12 August 2010

**REQUEST FOR ADDITIONAL INFORMATION
THOMAS STREET CAR PARK MP09_0066**

We write to you on behalf of the applicant, Welles Thomas, in relation to your email dated 23 July 2010 requesting additional information in relation to the proposed redevelopment of the Thomas Street Carpark, Chatswood. Our response is provided below, for ease of reference I have included your original comments (*italics*) with our response under each comment.

Solar Access Study

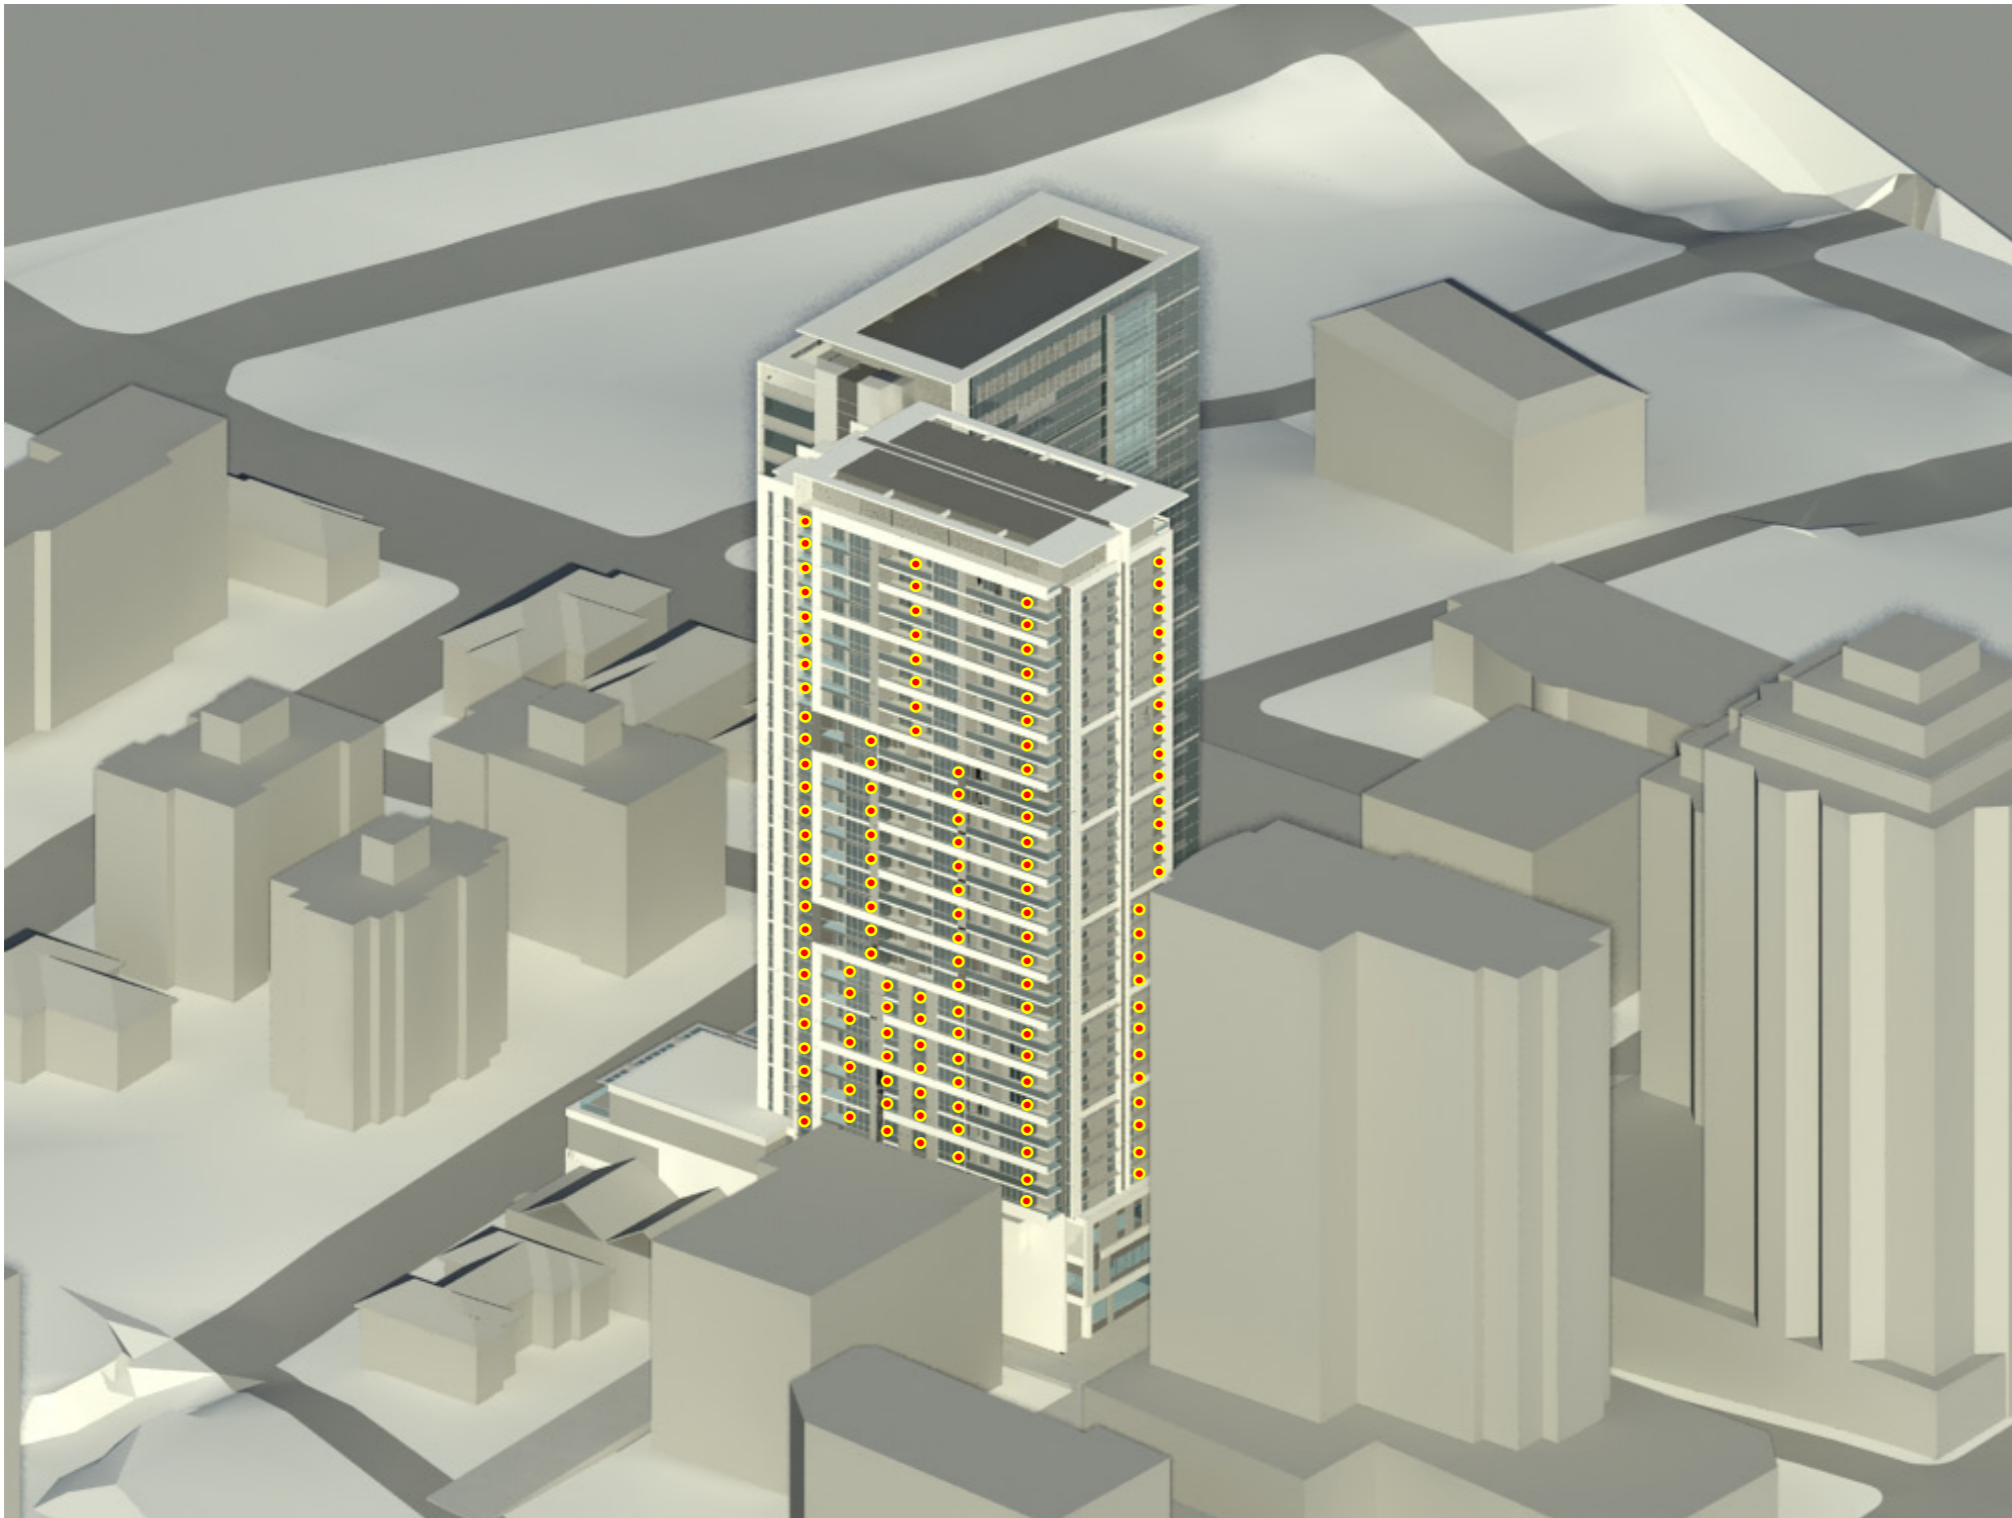
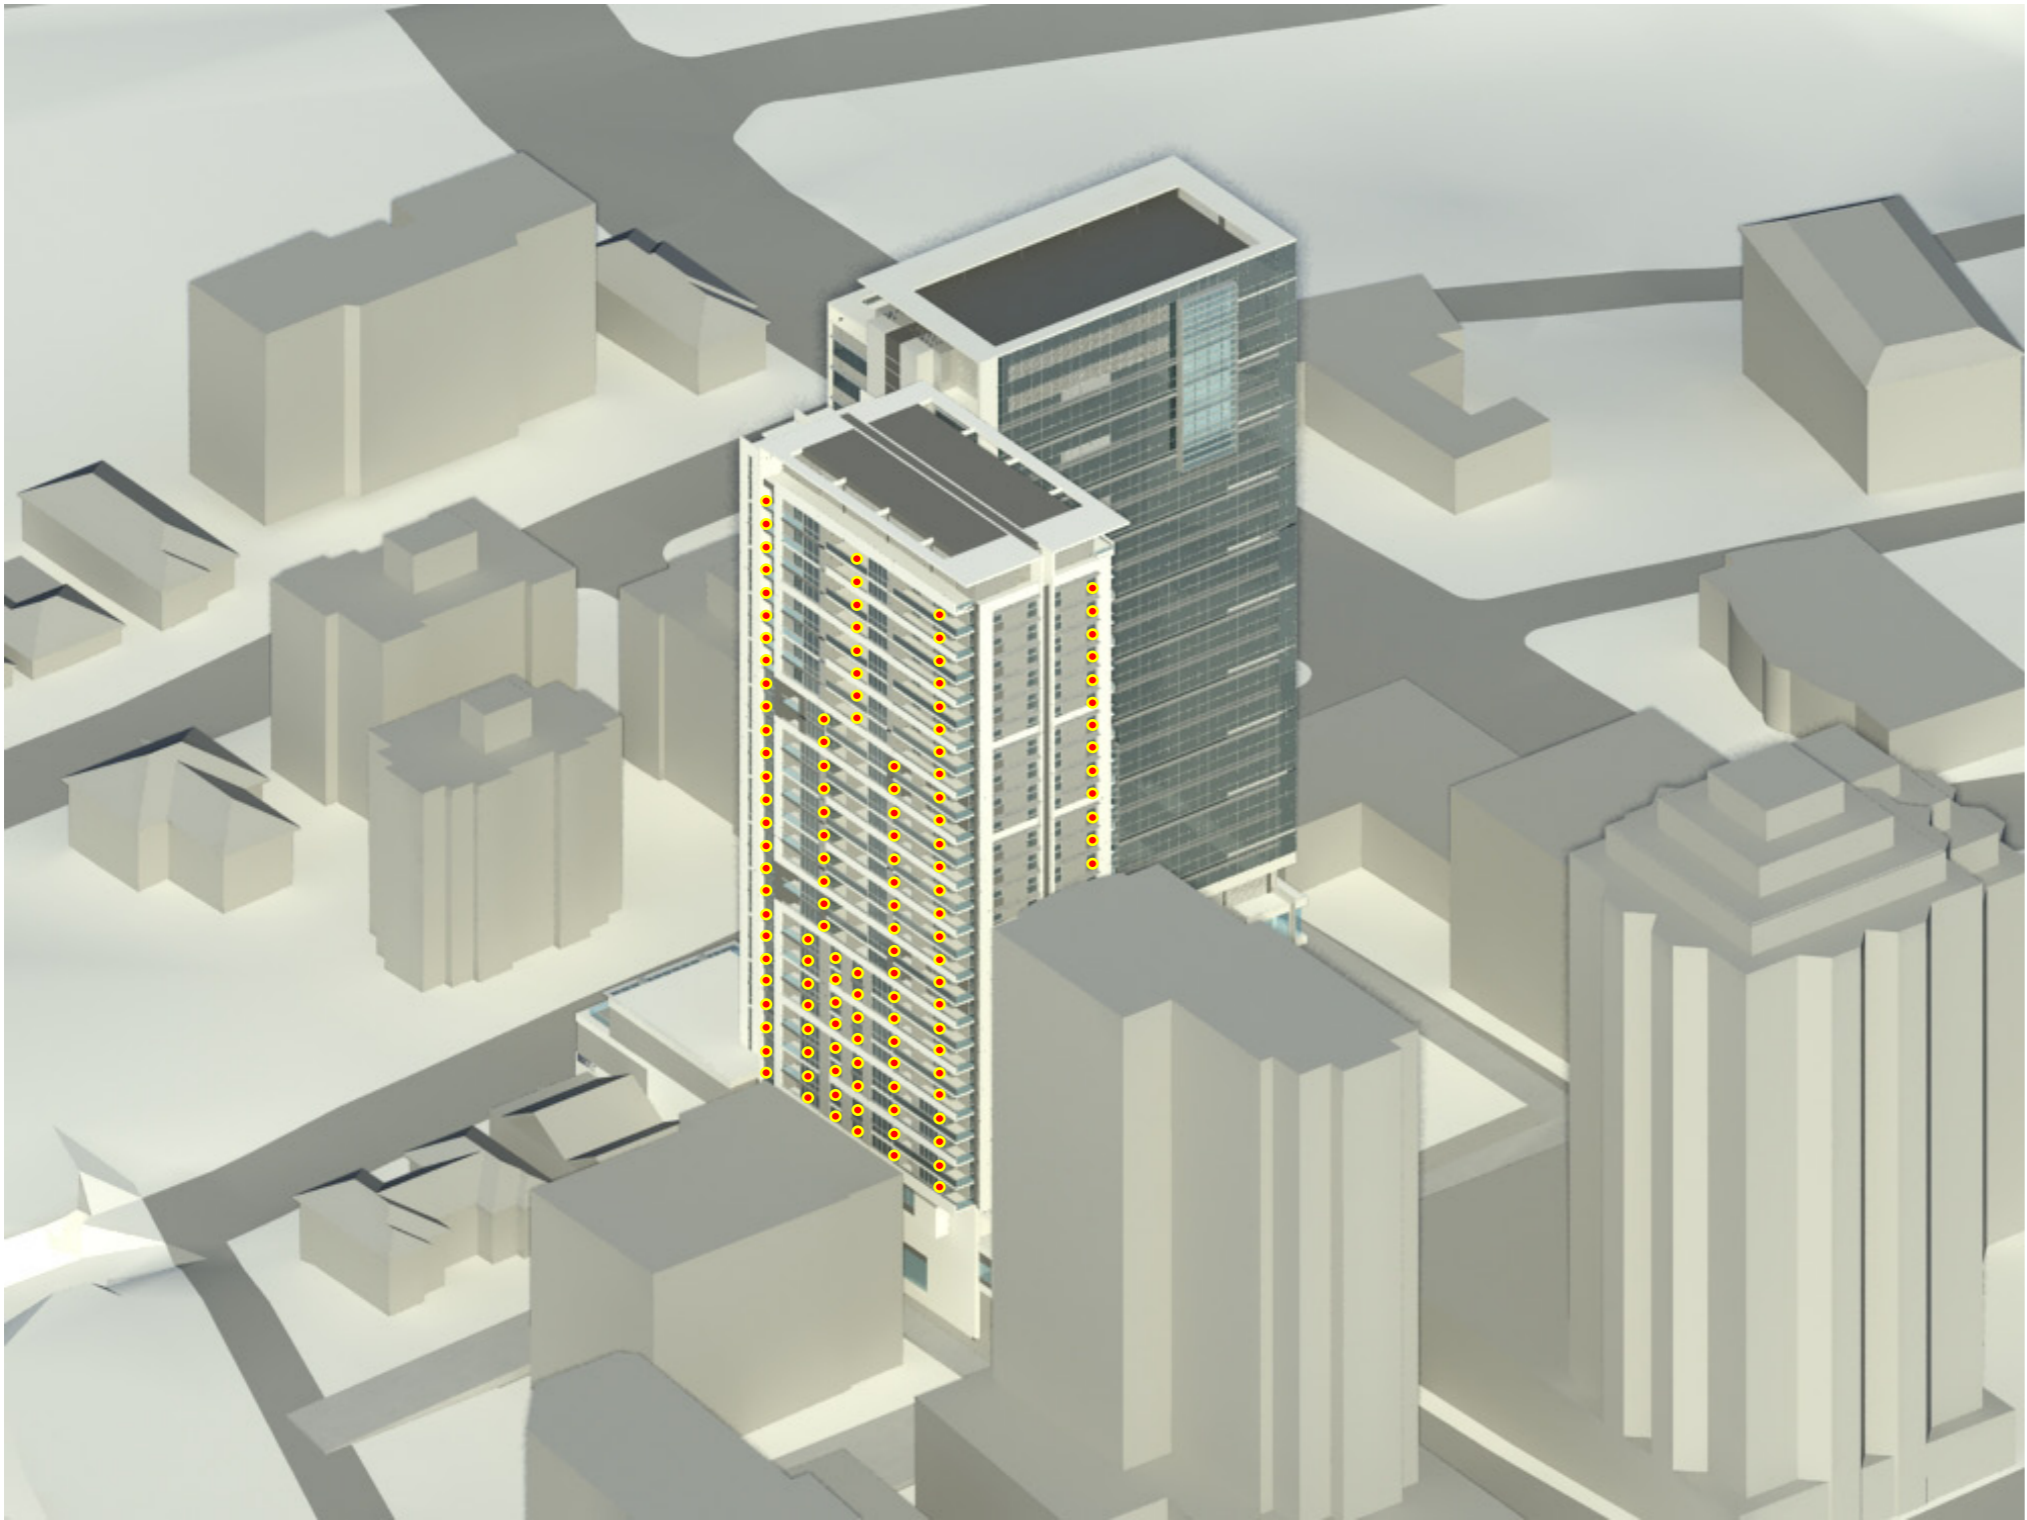
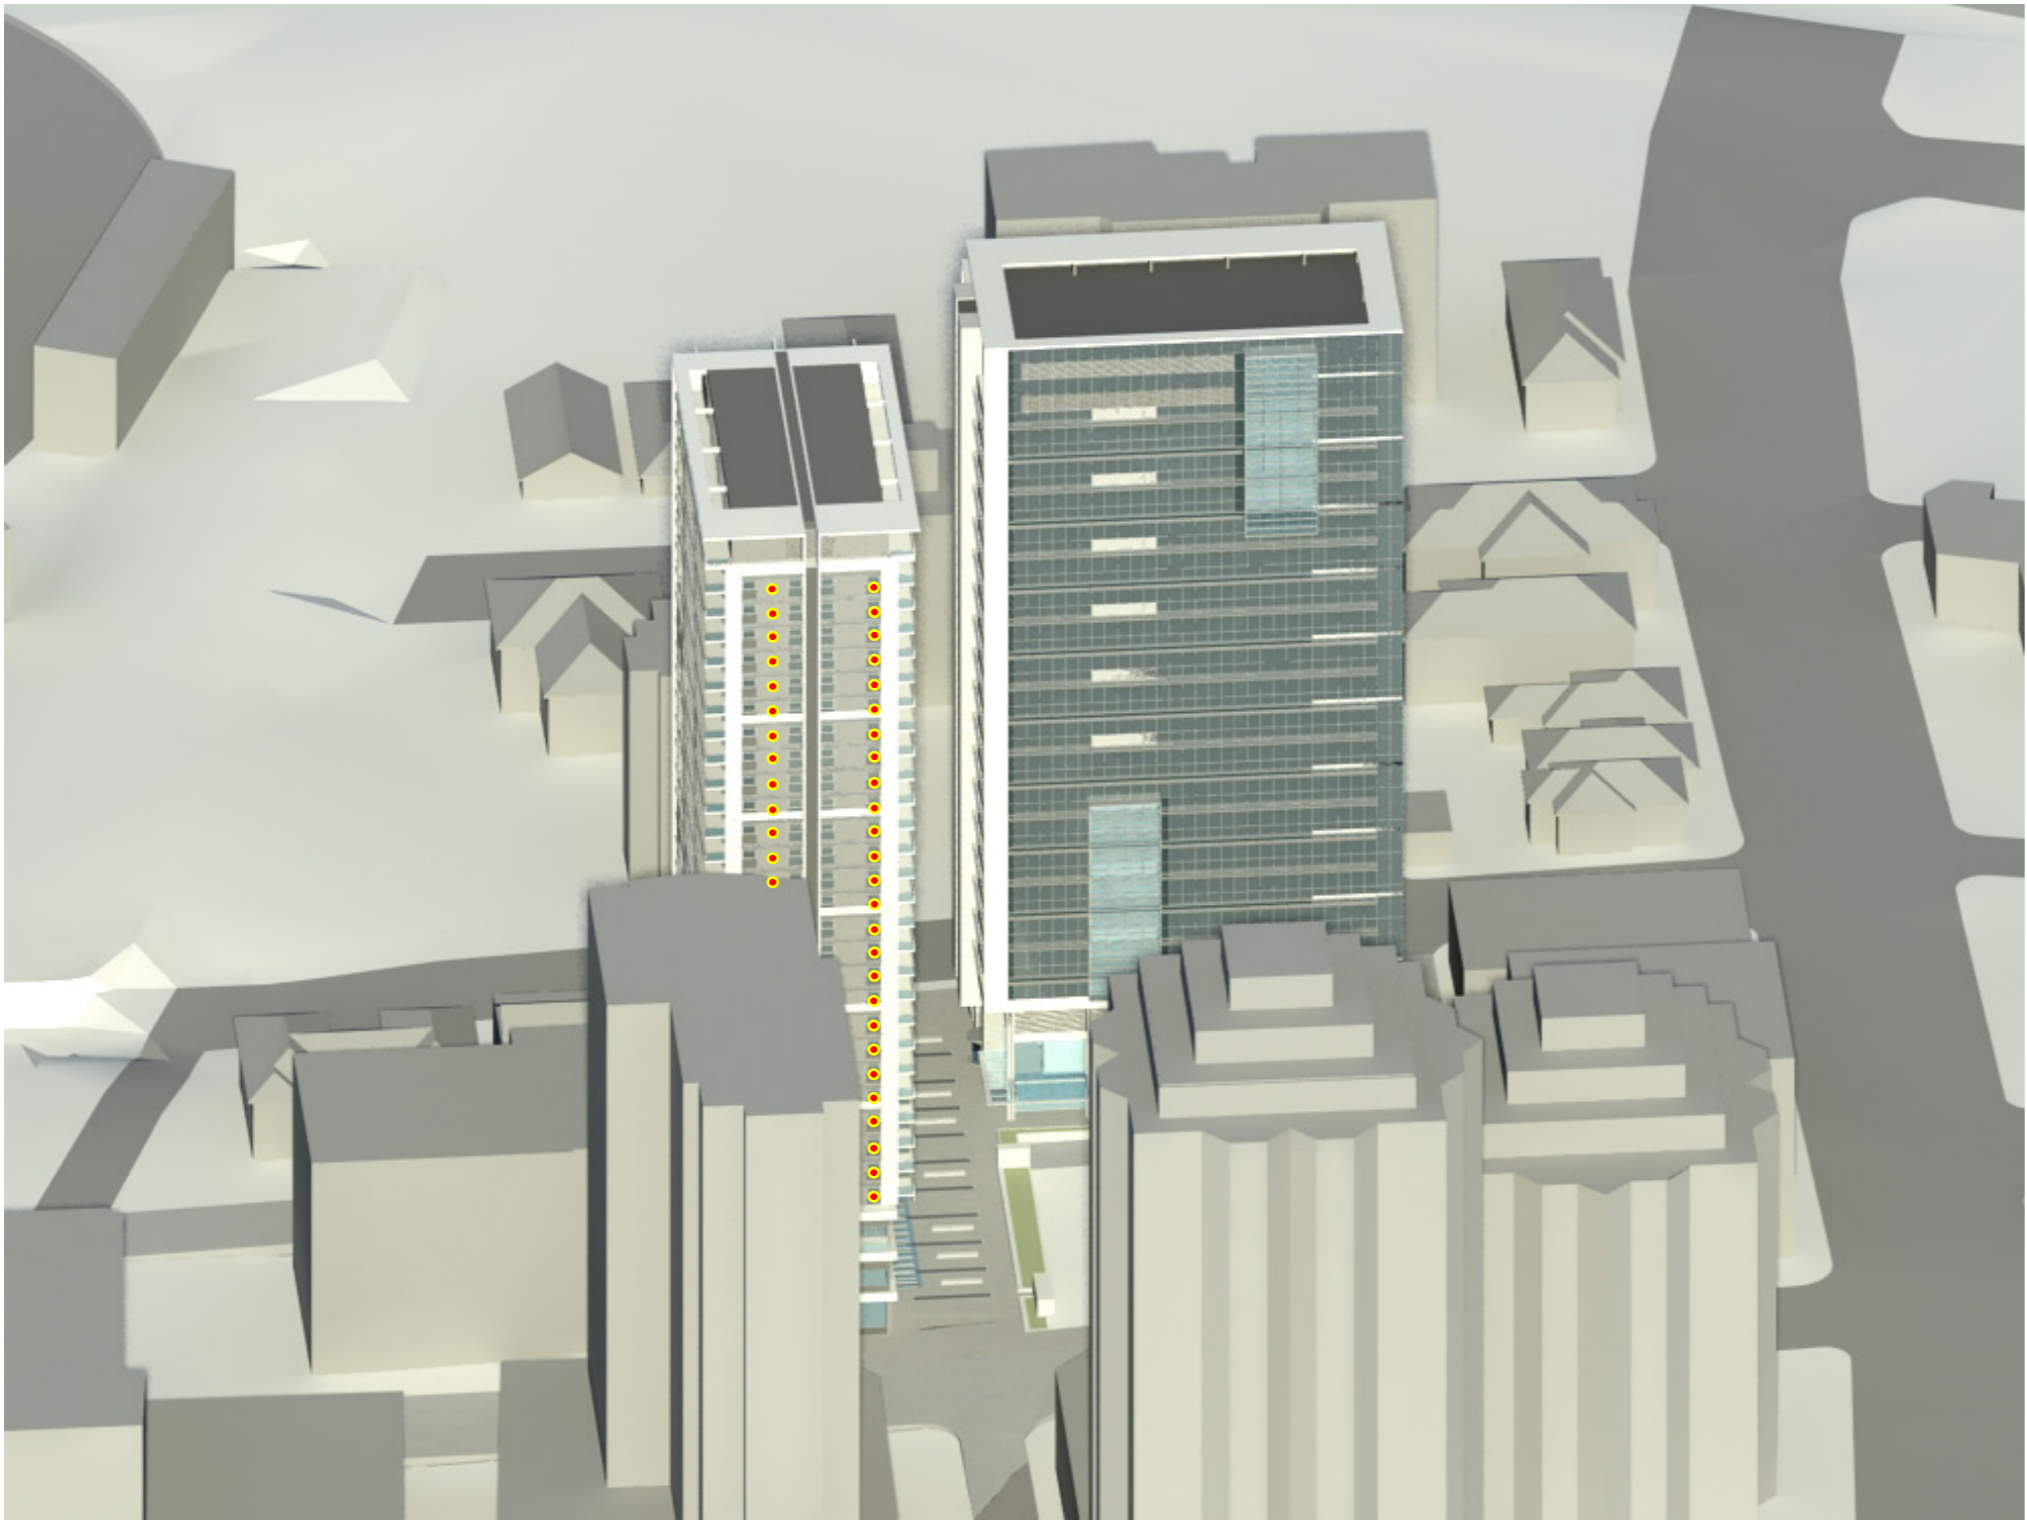
“Further analysis of daylight access for the residential apartments is required. It is noted that only approximate numbers of dwellings achieving solar access and natural ventilation are provided in the PPR. This further analysis should have regard to any overshadowing created by nearby buildings, the reduced number of apartments to 202 and the amendments to levels 3-5 (including louvered screens or any other further amendments to this facade).”

A suns-eye view of the solar analysis to the apartments is provided at **Attachment B**.
